**NELSON GEOTECHNICAL  
ASSOCIATES, INC.**

## **MEMORANDUM**

**RE:** Geotechnical Plan Review  
**Kendall Subaru Development**  
**16xxx Smokey Point Boulevard**  
**Marysville, Washington**  
NGA File No. 1378422

A geotechnical review of the plans was requested to verify the geotechnical aspects of the project meet the design recommendations provided by NGA.

GRADING PLAN C2.0

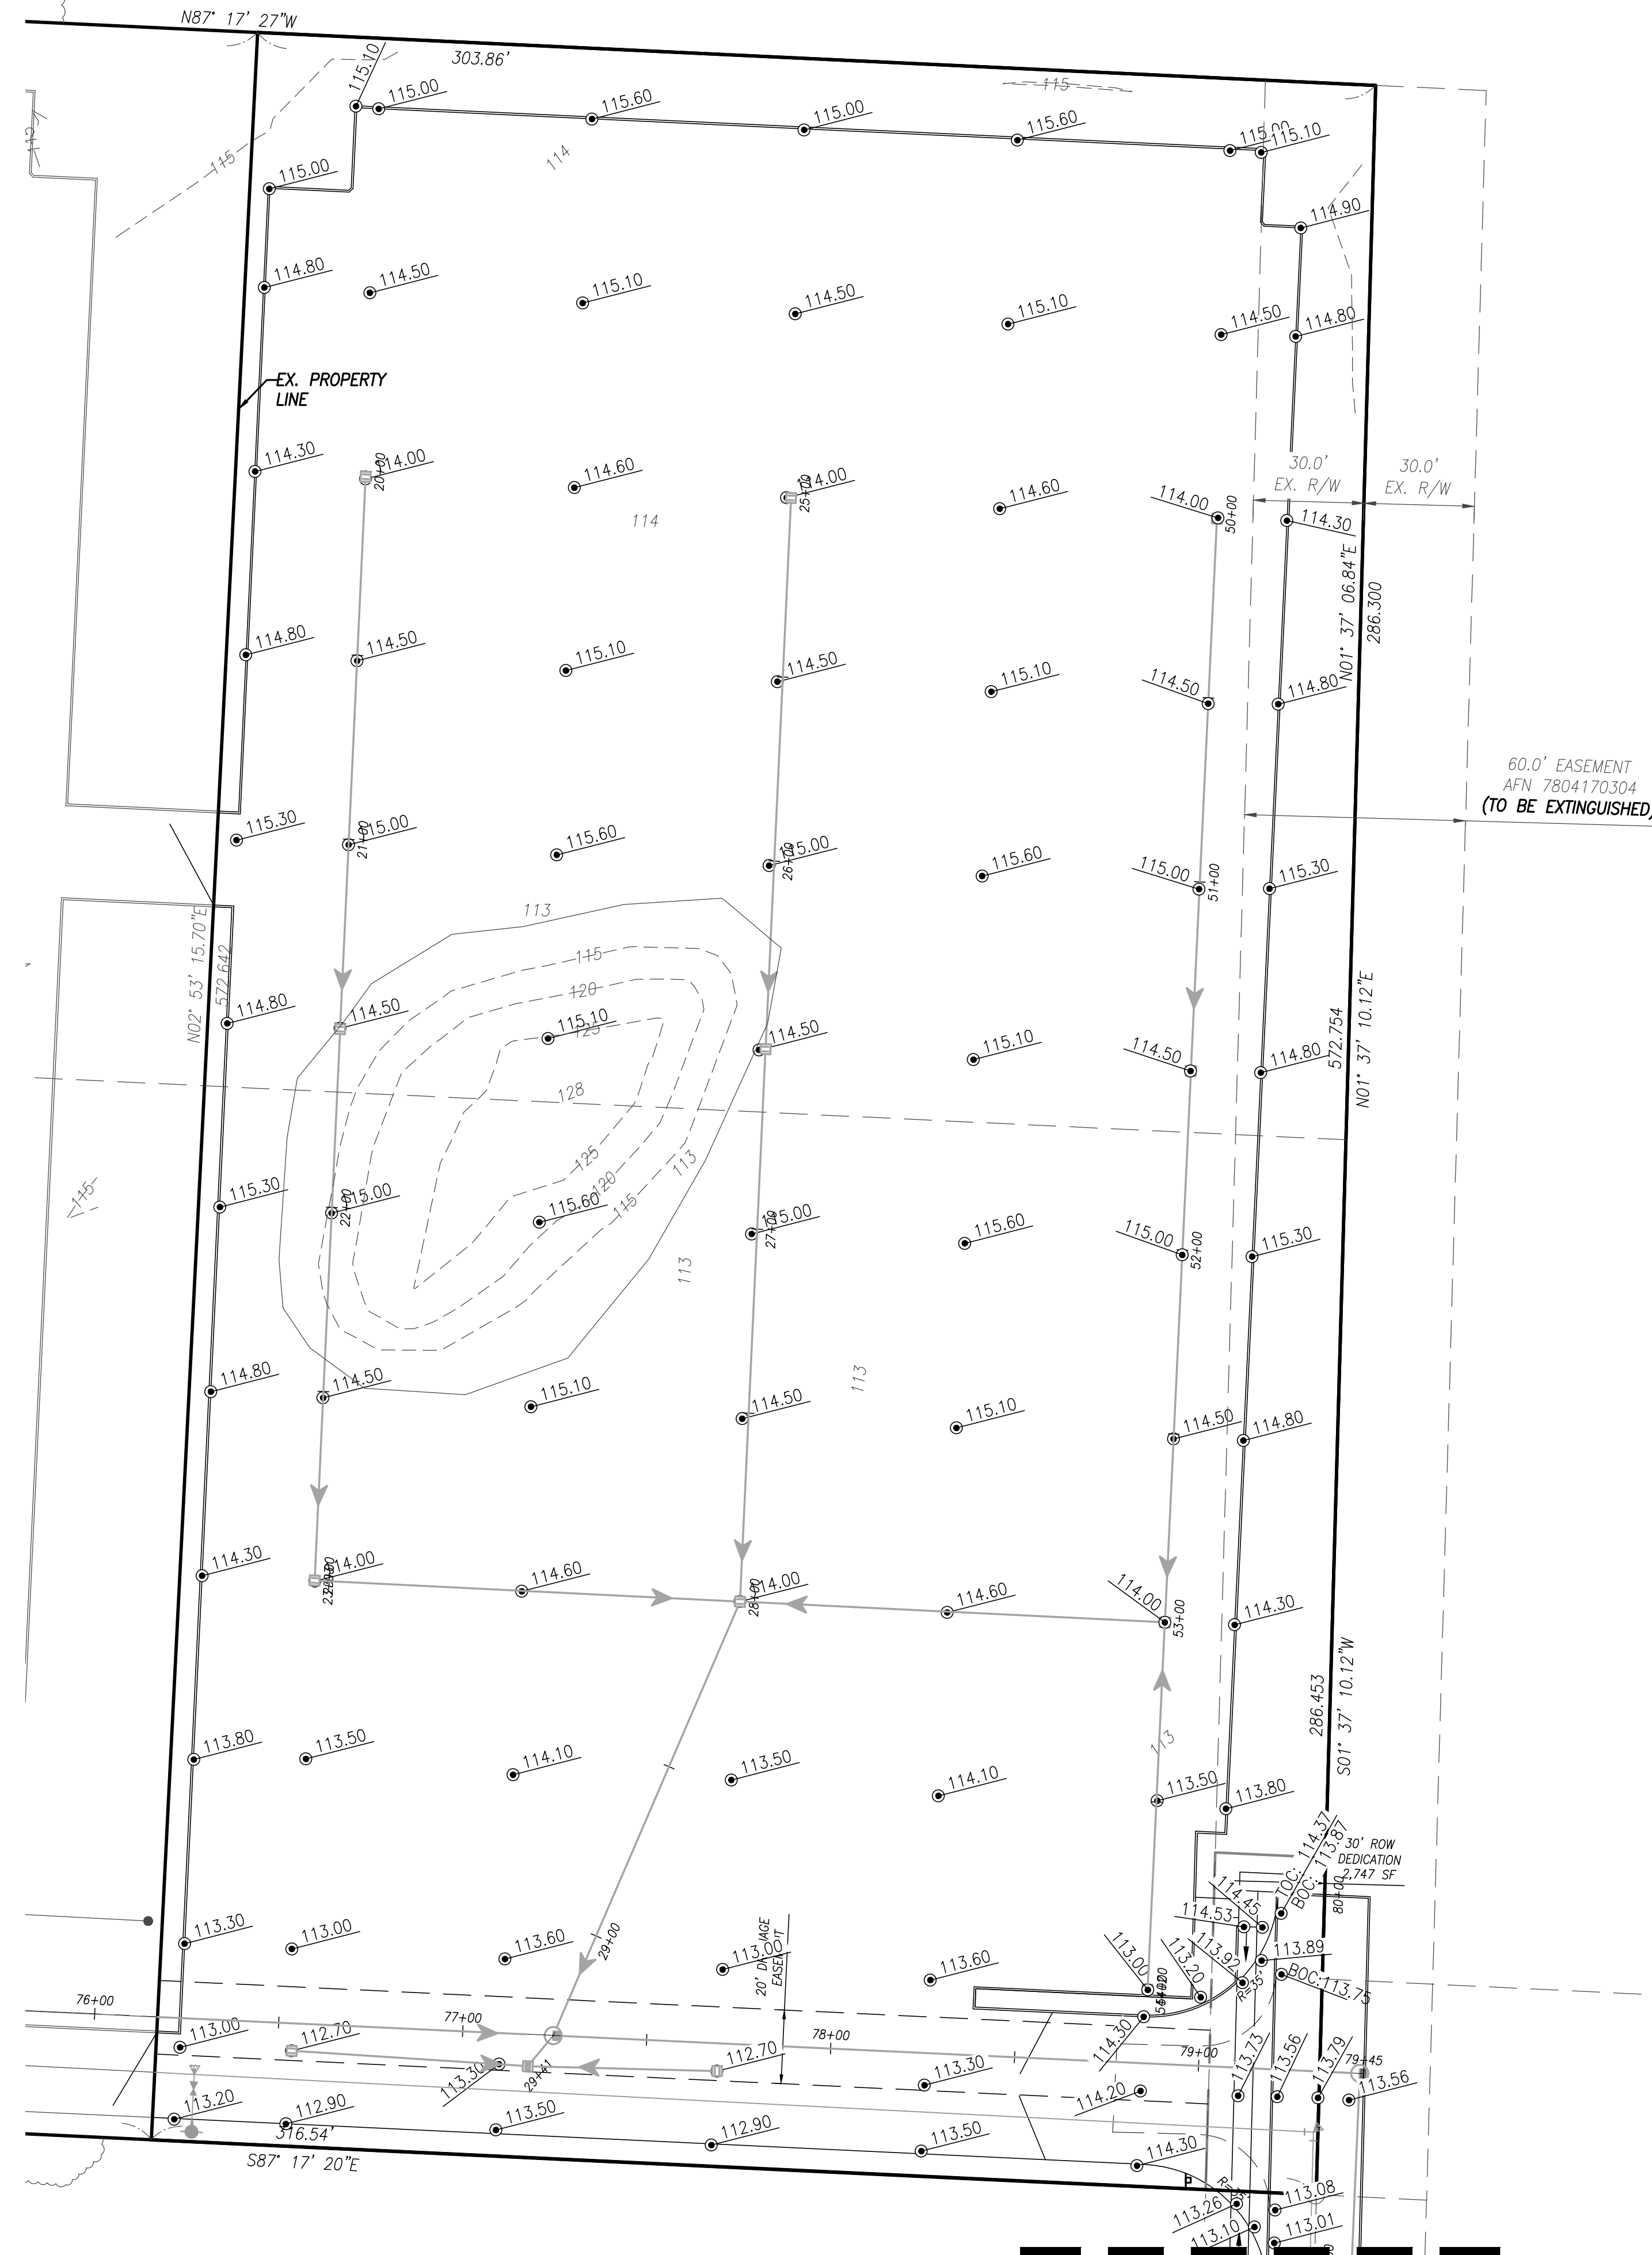
Per Civil Sheet C2.0, overall site grading should be relatively minor with finished floor of the planned building at approximately 115.5 feet and existing grades ranging from approximately 114 to 116 feet, however some imported fill will be placed along the building pad. Temporary sediment and erosion control measures appear to be adequate for the site and are shown to consist of silt fencing along the perimeter, standard construction entrance along the west central portion of the site, stockpile coverings, inlet protection, construction stormwater interceptor trench, and mulch or straw.

All stormwater generated from the proposed development is shown to be directed towards existing drainage infrastructure within Smokey Point Boulevard for the western portion of the site or 39<sup>th</sup> Avenue NE to the southeast of the site. Significant storm, sewer, and water infrastructure is planned for the development. Standard Detail 6 on Civil Sheet C6.2 specifies trench backfill should consist of crushed rock, gravel or excavated material. Fill placed in structural areas should be placed as structural fill and be evaluated in the field by NGA.
